**RE: FIRE STATION #11 (L18-D58) - GRADING AND DRAINAGE PLAN FOR  
BUILDING AND WORK ORDER PERMIT APPROVAL. ENGINEER'S STAMP  
DATED 2-2-98.**

**RE: FIRE STATION #11 (L18-D58). GRADING AND DRAINAGE PLAN FOR  
BUILDING AND WORK ORDER PERMIT APPROVAL. ENGINEER'S STAMP  
DATED 2-2-98.**

Re: Fire Station No. 11 (L18/D58)

Description  
 CONCEPTUAL  
 GRADING & DRAINAGE PLAN

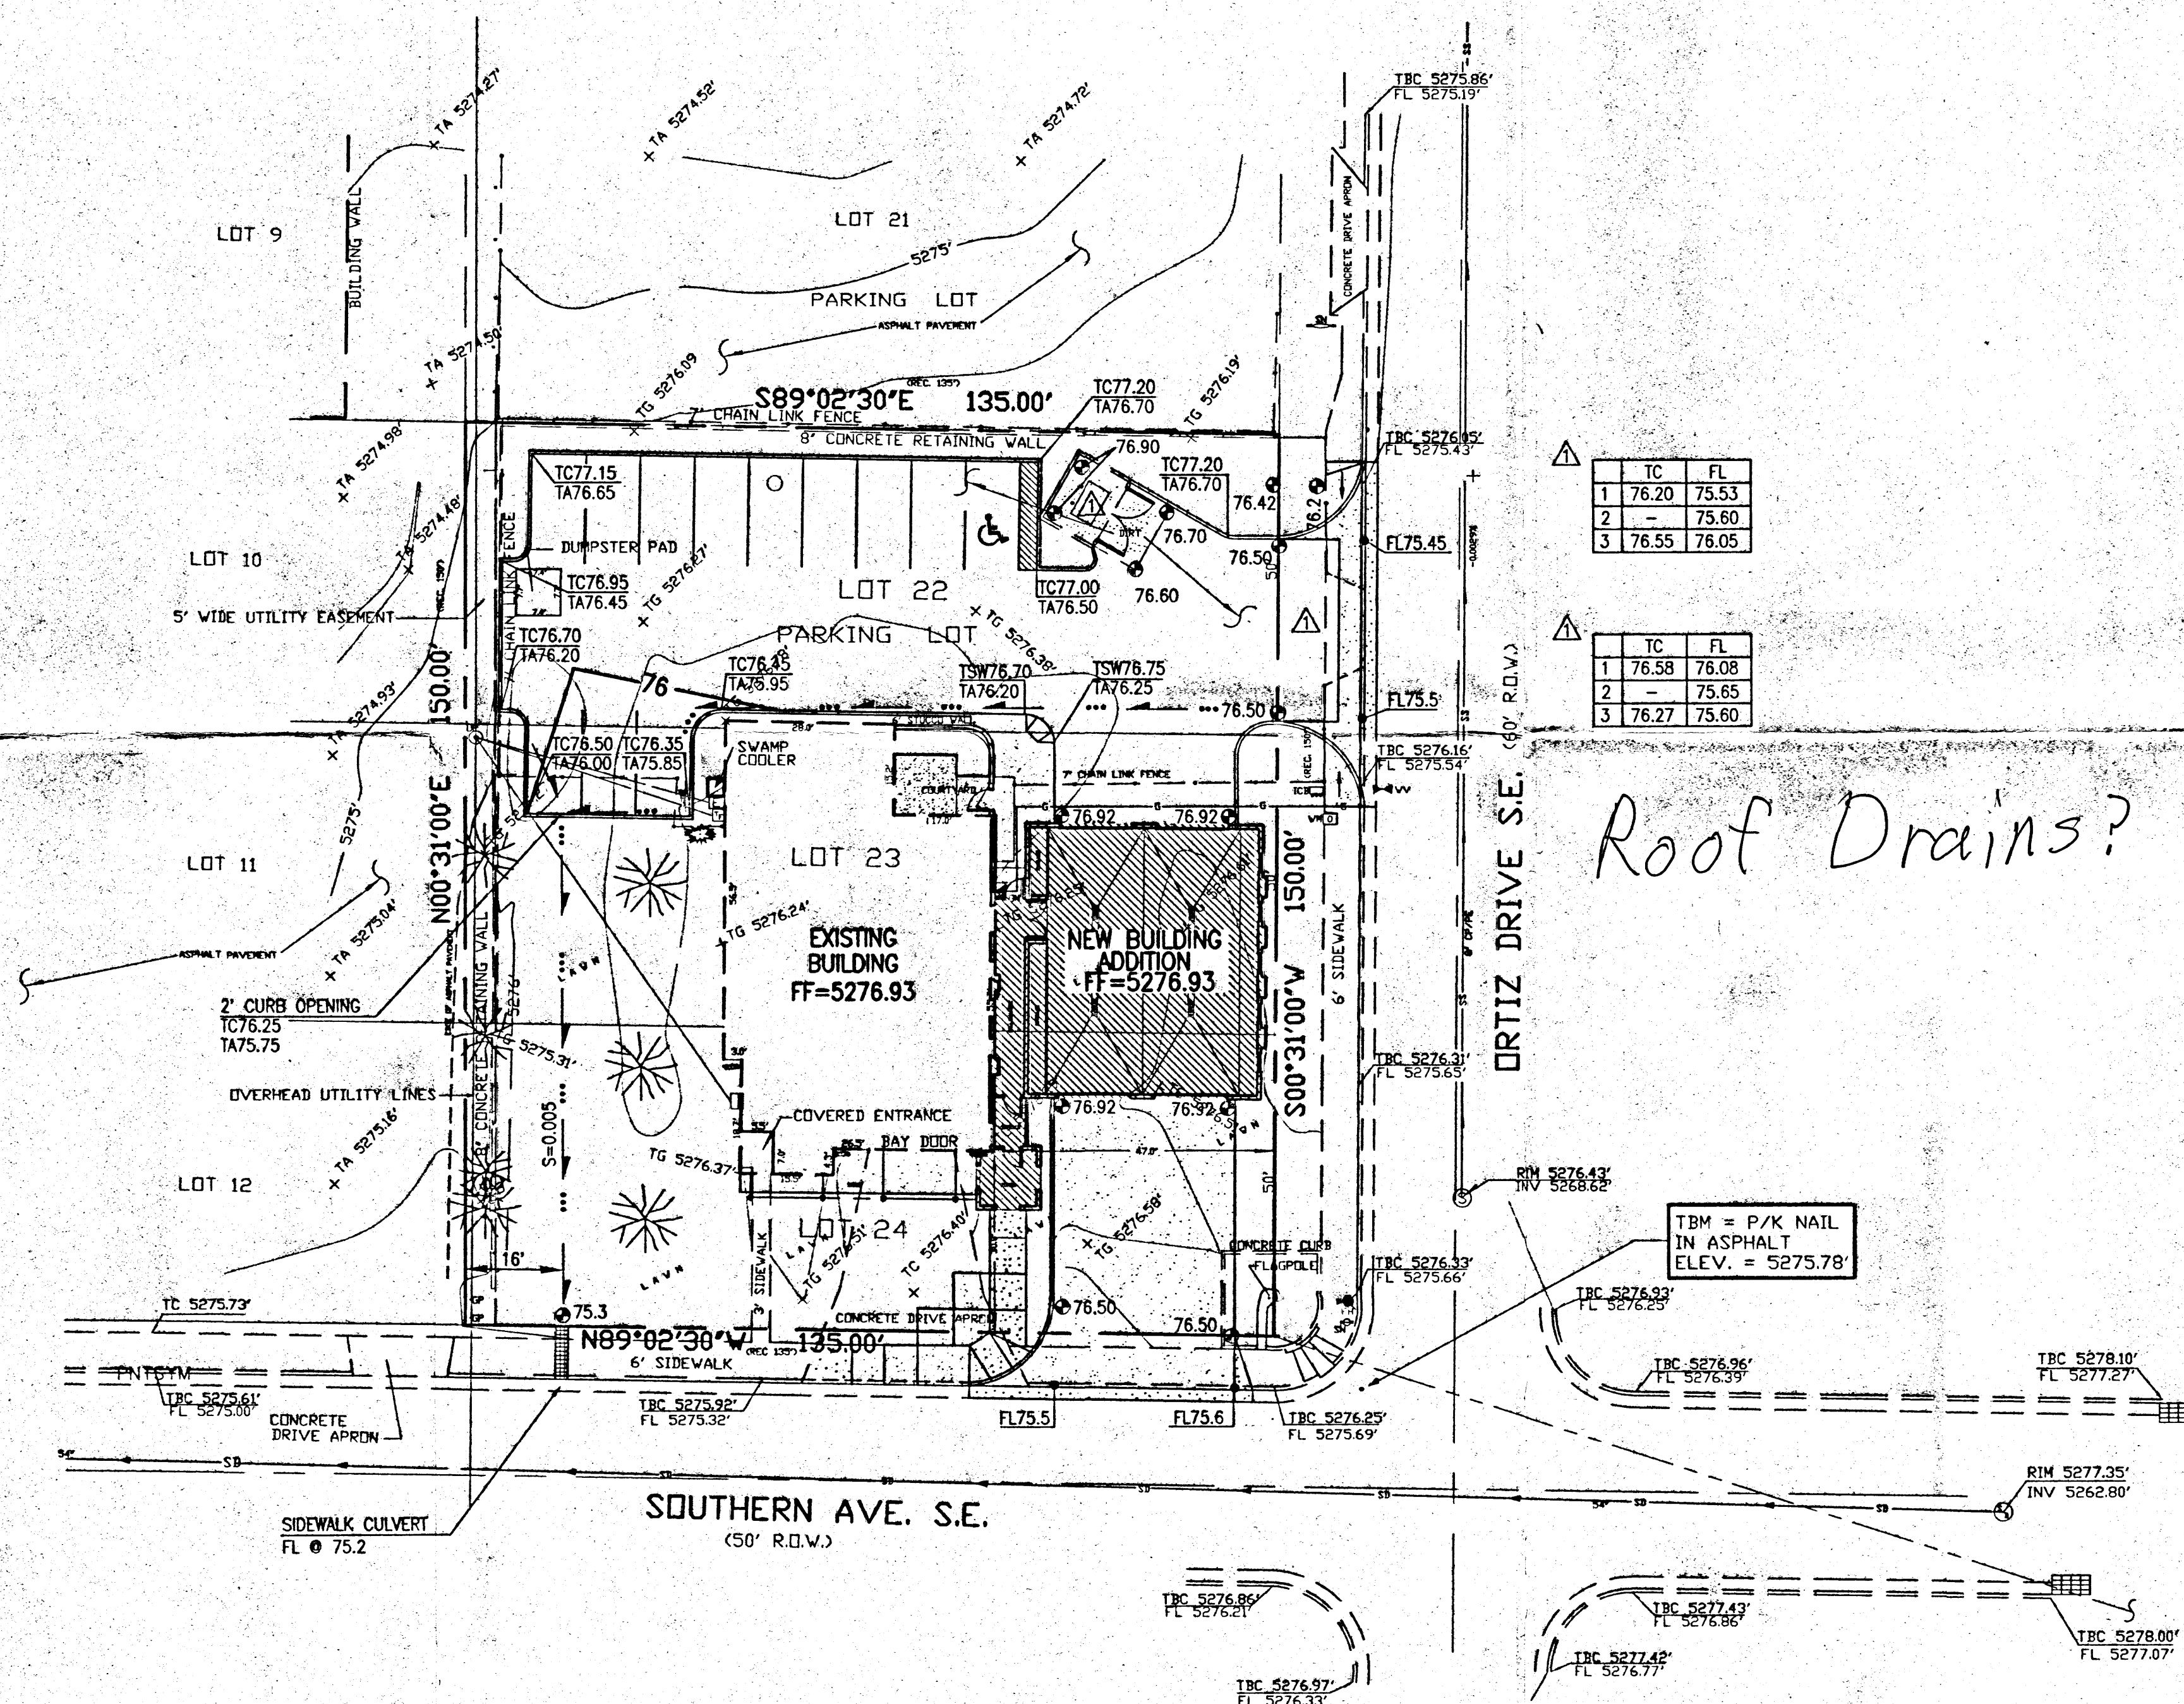
1. What is the flood elevation? Your finish floor should be 1-foot above the flood elevation. Provide a copy of the floodplain map on your plan sheet.
2. Why are you requesting a Work Order Permit?

Based on the information included in the submittal referenced above, City Hydrology accepts the Conceptual G & D Plan for Site Dev Plan for B.P. Indicate the location and direction of the roof drains prior to Building Permit.

Please be advised that prior to Building Permit release, you must indicate the location and direction of the roof drains.

1. The floodplain associated with the project is located within the street. The floodplain has been effectively removed by construction of public storm drains by the City. Furthermore, the main building of the fire station is existing. The addition will house vehicles. For accessibility reasons, the finished floor of the addition must match the existing structure.
2. Work Order approval is requested due to the fact that this is a City project. It is my understanding that all City projects must be reviewed and approved at DRC.
3. Attached are copies of the previous comments set forth when the Conceptual Plan was approved.
